**RE: Review Comment Responses / 12057 Highway 24 Multifamily Rezone
El Paso County, Colorado**

The purpose of this letter is to respond to the County Staff review comments (1st Review). We have provided detailed responses to the review comments and made revisions to the Traffic Impact Study. We remain available to discuss further if needed. The following is a summary of comment responses:

Figure 3
BACKGROUND TRAFFIC - YEAR 2028
 Volumes & Intersection Geometry
 AM / PM Peak Traffic Hour
 (ADT) : Average Daily Traffic

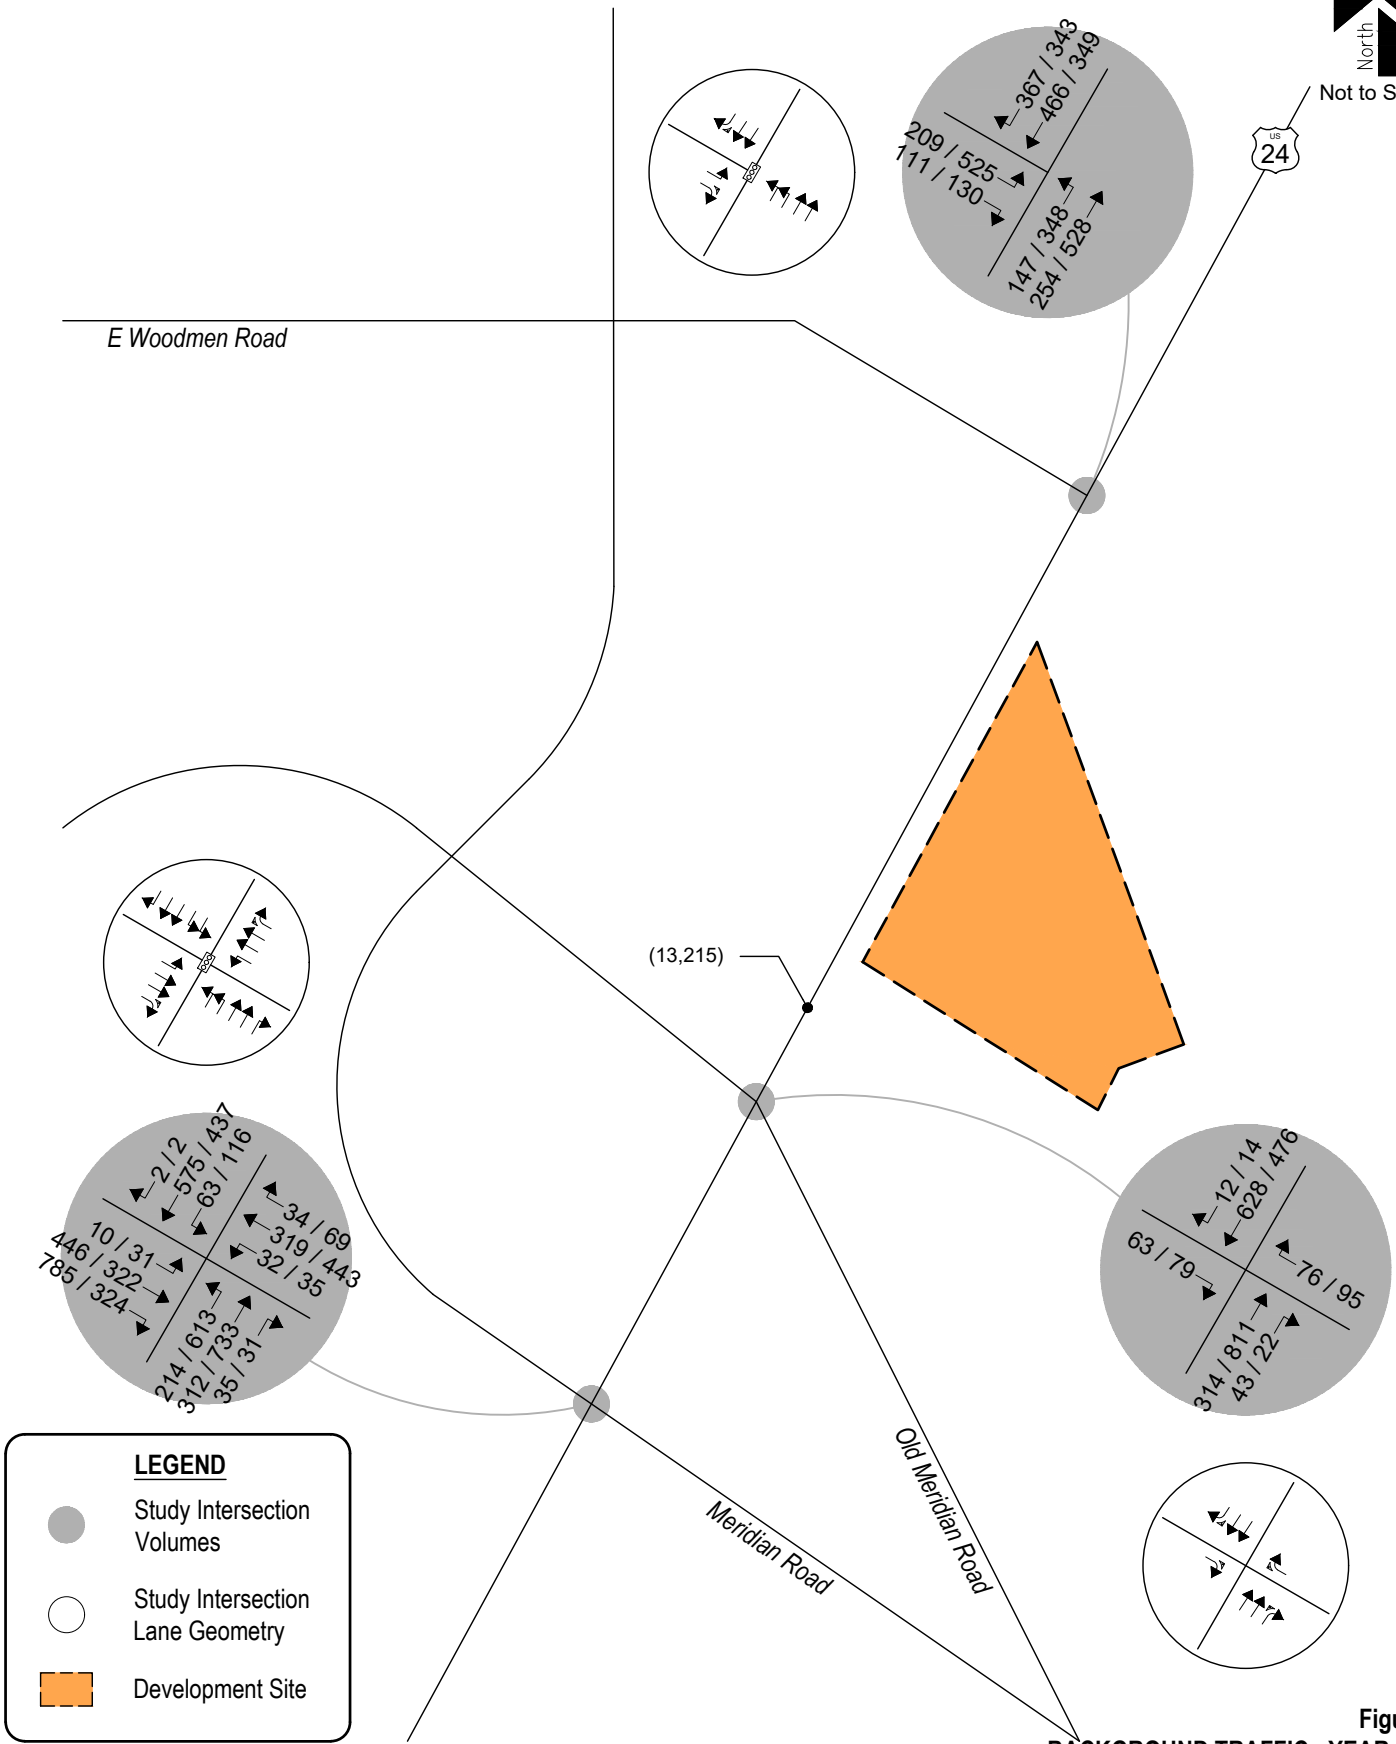
County Comment 7: This appears low in comparison to other traffic studies in the area. Please be sure to account for other developments in the area specifically Falcon Field development at Woodmen/Hwy 24 (PCD File No. SP232, SF2435). Update the analysis as necessary.

Comment Response: Falcon Field development added, please know that due to EDARP limitations it is difficult to find every study within a certain development area. If further traffic studies are requested to be considered, please provide where necessary.

Figure 4
BACKGROUND TRAFFIC - YEAR 2045
Volumes & Intersection Geometry
AM / PM Peak Traffic Hour
(ADT) : Average Daily Traffic

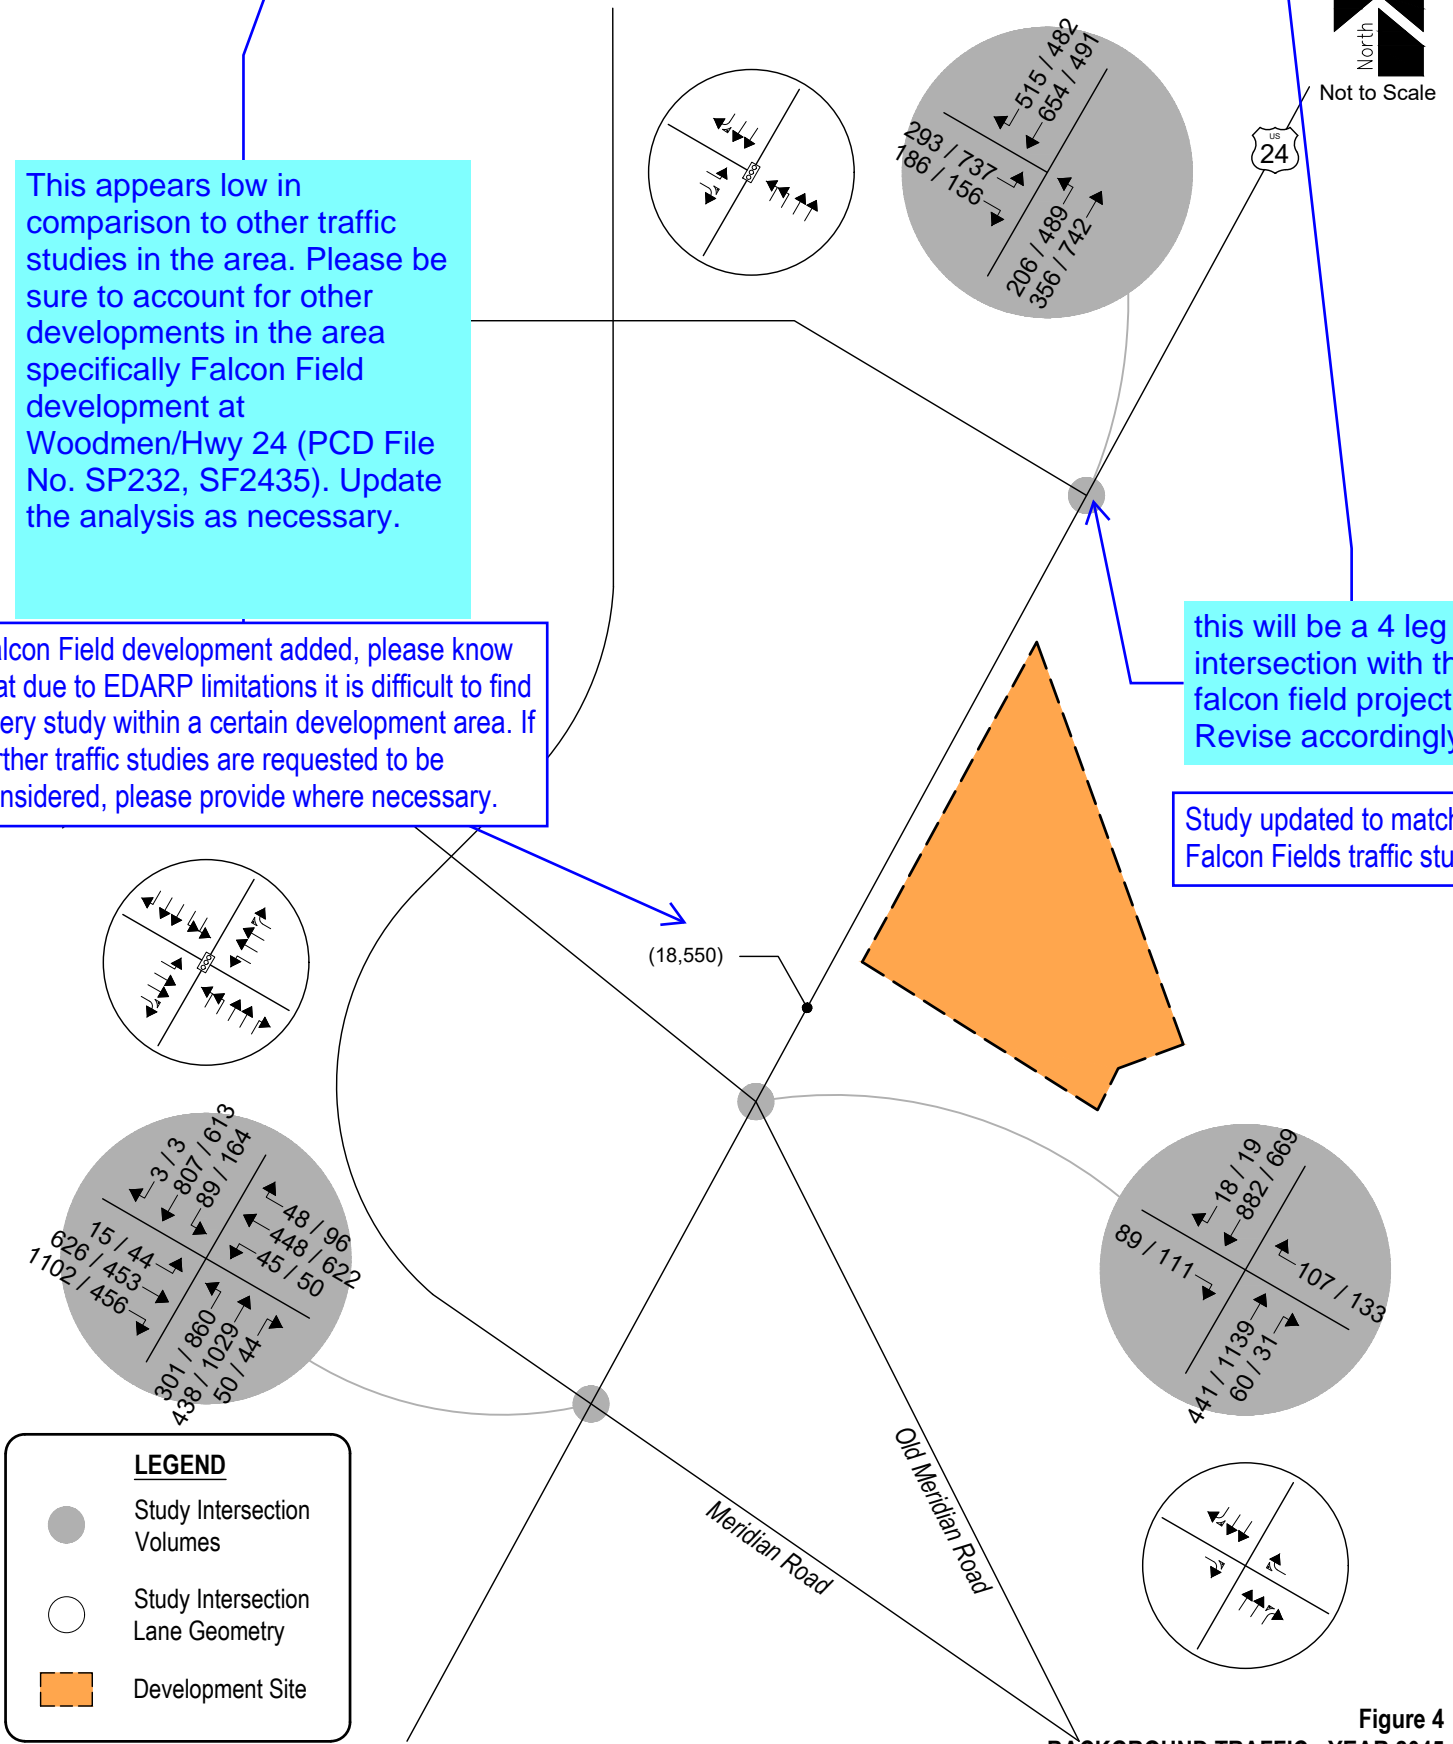
County Comment 8: this will be a 4 leg intersection with the falcon field project. Revise accordingly

Comment Response: Study updated to match the Falcon Fields traffic study.
